From: Sarah Burrow <Sarah.Burrow@arun.gov.uk>
Sent: 10 January 2020 09:17
To: Andrew Wood <Andrew.Wood@arun.gov.uk>
Cc: Planning.Responses <Planning.Responses@arun.gov.uk>
Subject: RE: Planning Consultation on A/132/19/DOC

Engineers Comments Regarding Surface Water Drainage

APPLICATION NO: A/132/19/DOC

Site Address: Merry England Nursery Dappers Lane Angmering BN16 4EN

DRAINAGE LEGEND (1:200)

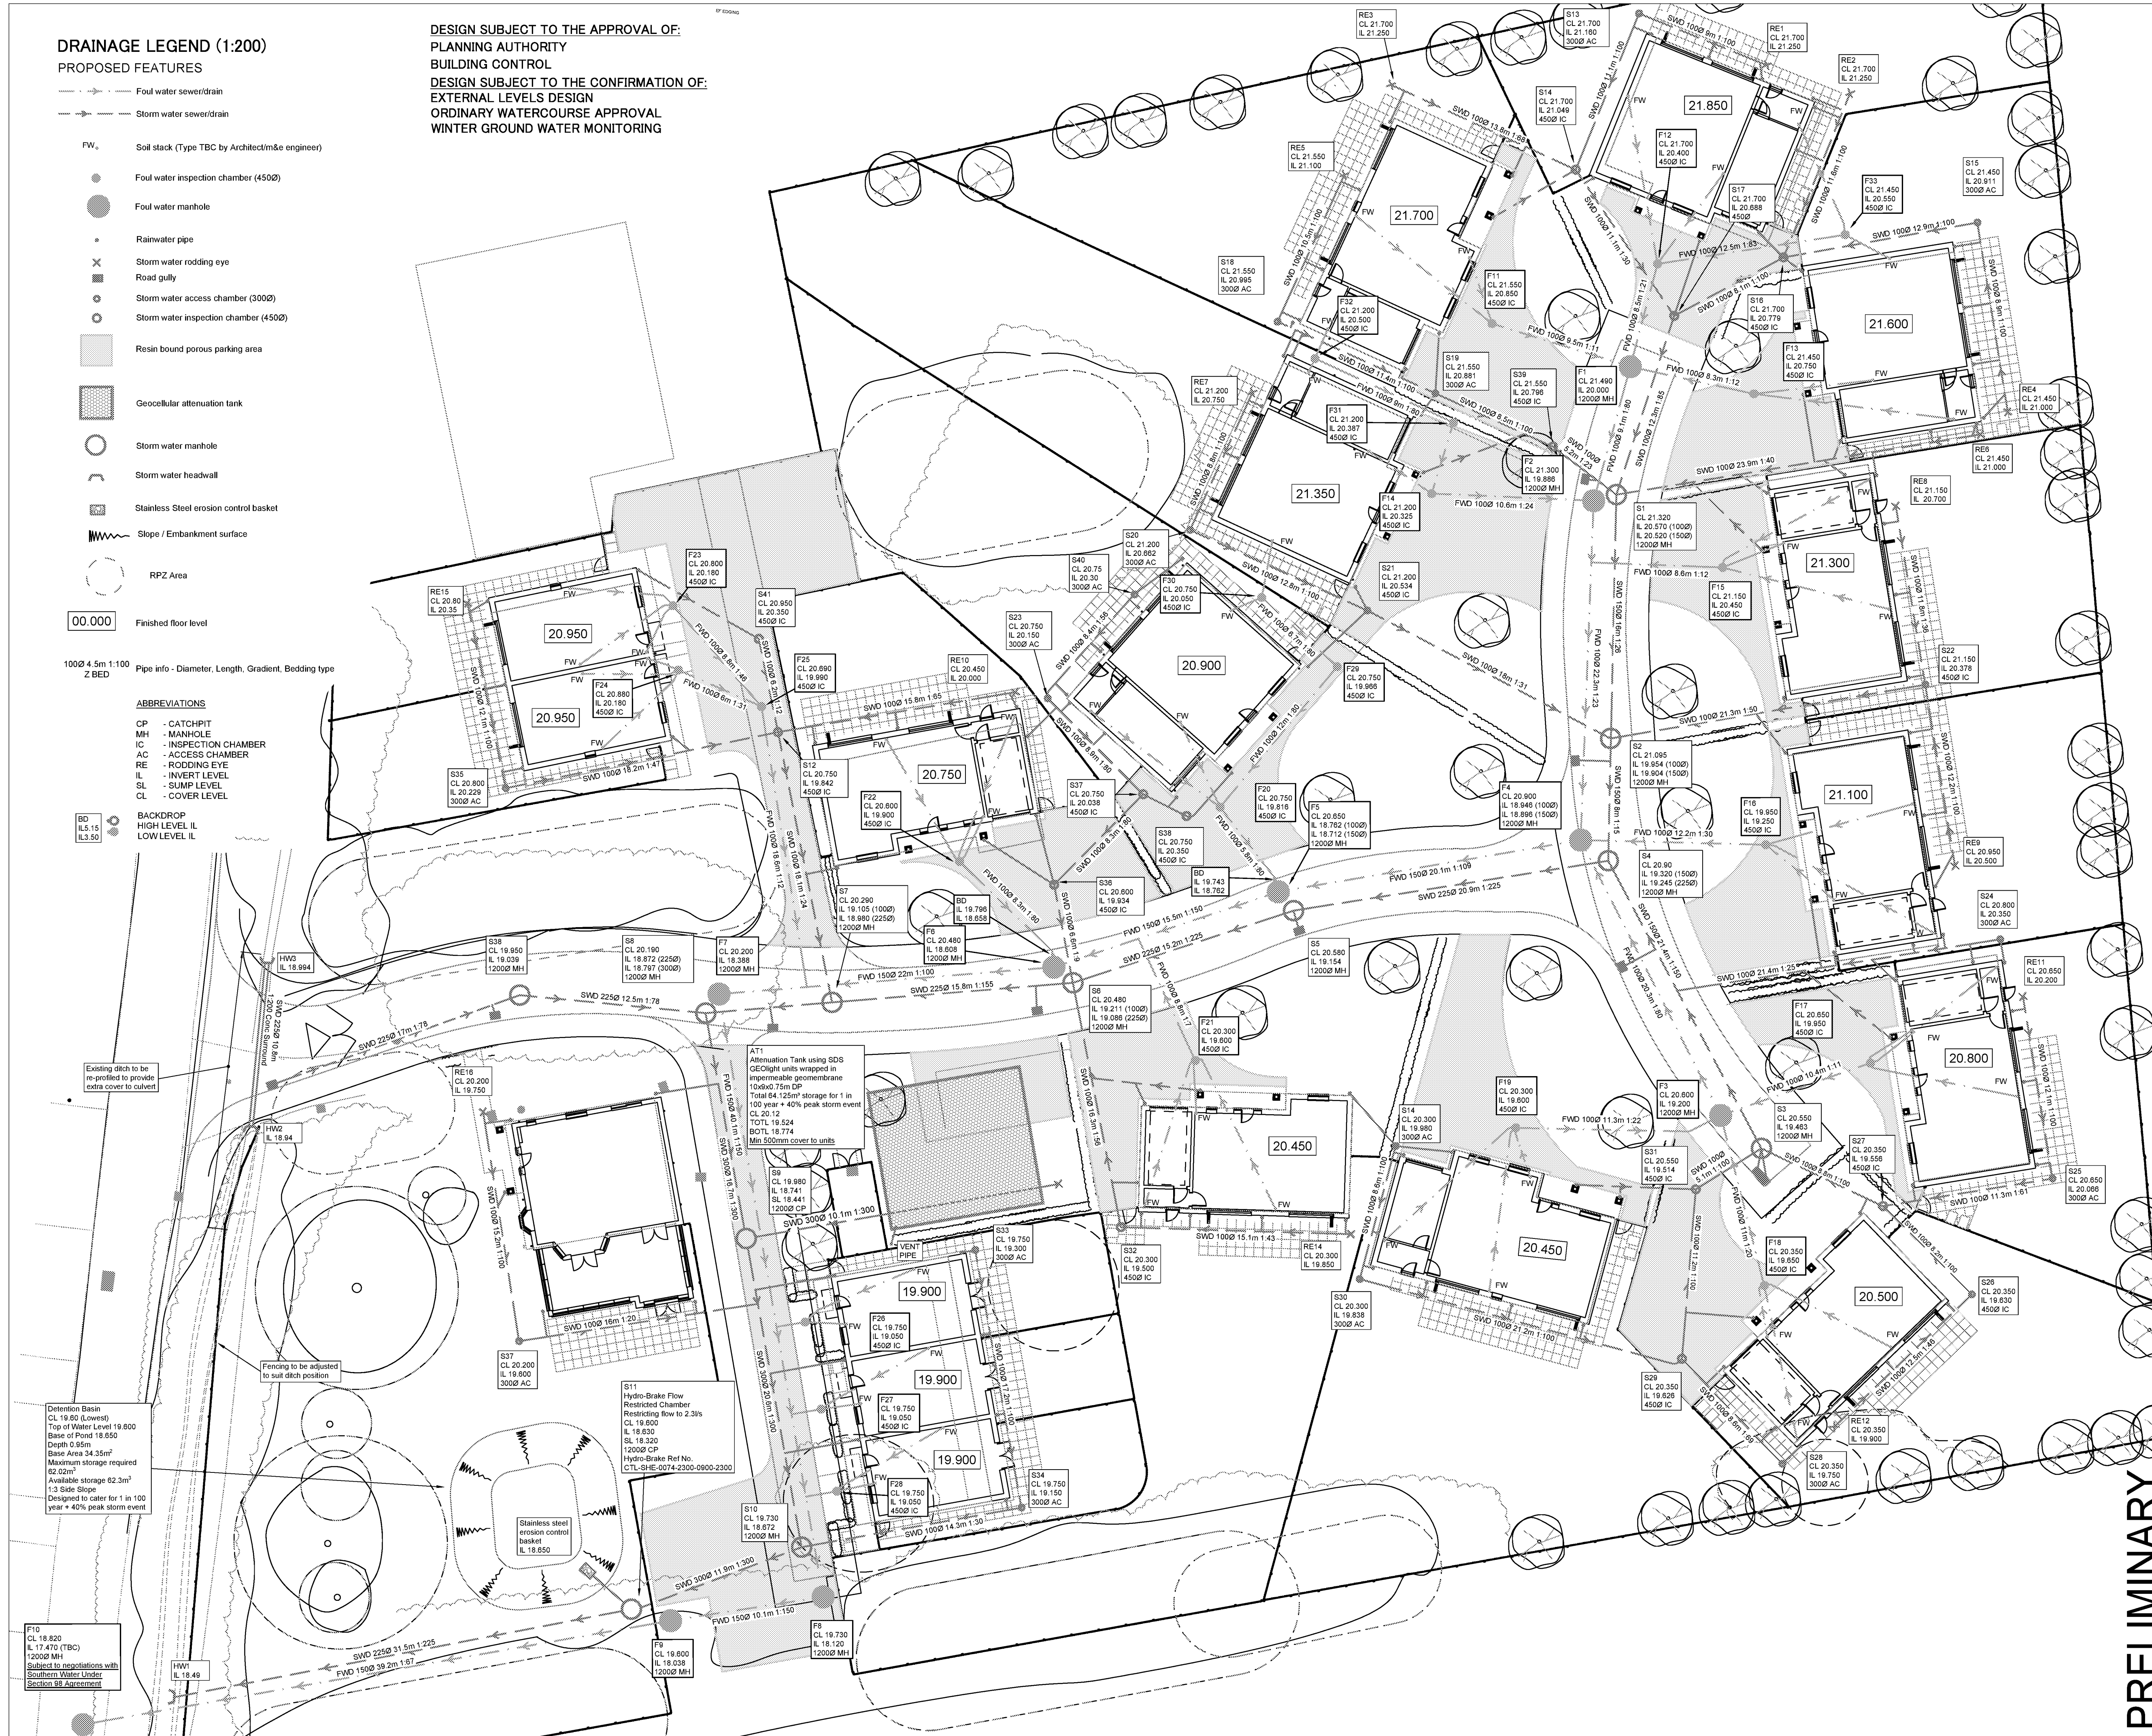
3. There should be a manhole/inspection chamber between S3 and S4 where surface water from two units join the network.
4. Pipe materials need to be covered in notes.

5. The attenuation tank detail should show one pipe for flows both entering and leaving the tank at the base. A vent pipe is required for the smaller tank.

6. If there is any risk of heavy vehicles parking over the large attenuation tank then the cover level needs to be 650mm.
7. Need a sump manhole detail for S9 and S10. (S10 not currently shown as a catch pit manhole but it is recommended that this is changed as the Hydrobrake does not have a full catch pit only a small sump.)

8. Buoyancy calculations are required for both tanks – the only mention of these is that they will be covered in a later addition.
9. Pipe diameter and invert levels are required for S11 to tank.

10. Hydrobrake manhole detail needs more detailing, i.e. Ring diameter, cover type, brickwork etc, similar to type B detail. Pipe diameters on the detail are incorrect.

11. Note 15 on the plan – add D400 required in carriageways (access road).
12. Junction detail – Square is not permitted, the junction must be oblique and is applicable to pipes of equal diameter or not.

13. Detail required for the concrete baffle just beyond S10.
14. Permeable pavements – specify finished levels/base (formation) levels on plan.
15. Detail required for proposed land drains – some plots don't have one, amend to help with run off from patios.
